### ADC Planning Consultation Response from the Conservation Officer

| <b>Application Number</b> | AB/61/13/                                                                                                  |
| <b>Address</b>            | 9A Tarrant Street Arundel BN18 9DG                                                                         |
| <b>Description</b>        | Installation of window to flank wall.<br>This application affects the setting of Arundel Conservation Area |

PROPOSED SIDE
ELEVATION SHOWING
WINDOW (NORTH)

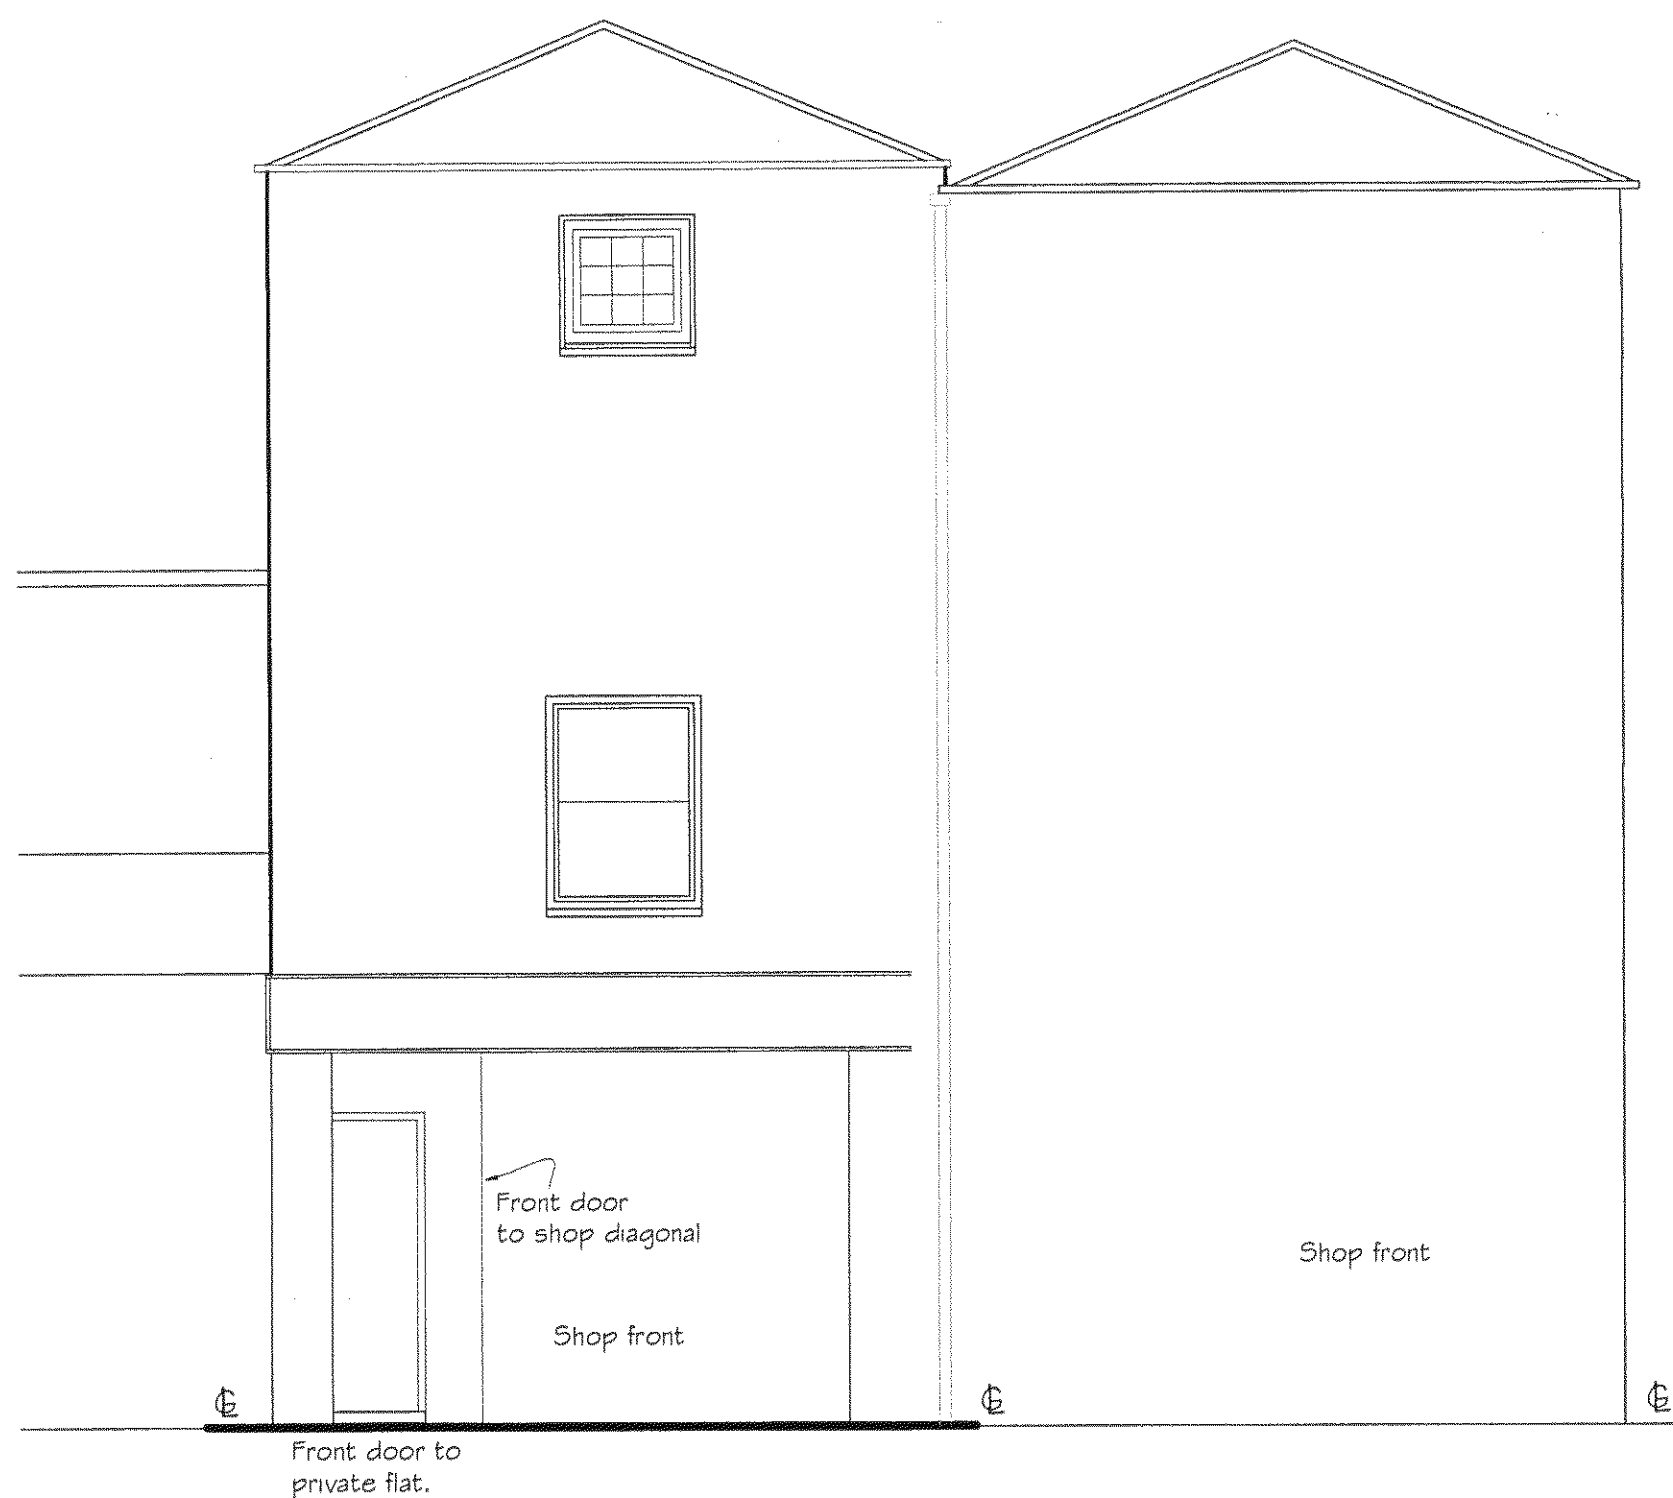
The proposal is to insert a window in an elevation where none currently exist. The application states that it is needed to introduce extra light into the property. Its location is such that it has the potential to be viewed from Tarrant Street which has the potential to impact upon the conservation area. However, the location of the property along with the window is such that there should be little opportunity to view it from the street-scene. This would therefore reduce its impact.

Consequently, should the application be approved, it is recommended that for its impact is minimised, the window will have to be of high quality i.e. matching those of the other windows in the property.

As it currently stands, there is little information provided with regards to the window detail, this should be conditioned as part of any approval.
